Please find below our comments on the proposed planning application reference: BE/40/22/PL

We would currently recommend a Holding Objection until sufficient information is provided.

SOIL PERCOLATION TEST SA1

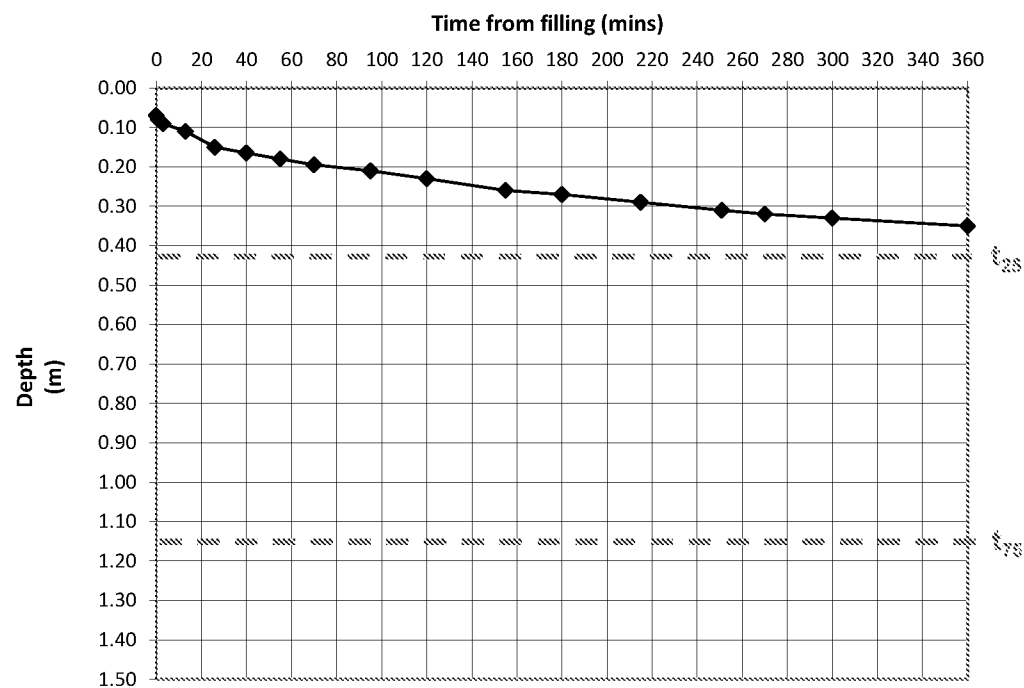
- The infiltration testing that has been carried out does not show drain down times from 75-25% across all 3 tests, as in most cases a single test has been carried out. If the permeable surfacing / paving with infiltration is included in the detailed design, BRE 365 compliant infiltration tests will be necessary to support the calculations. This area cannot be excluded from the impermeable areas in the drainage model unless this additional testing is carried out.
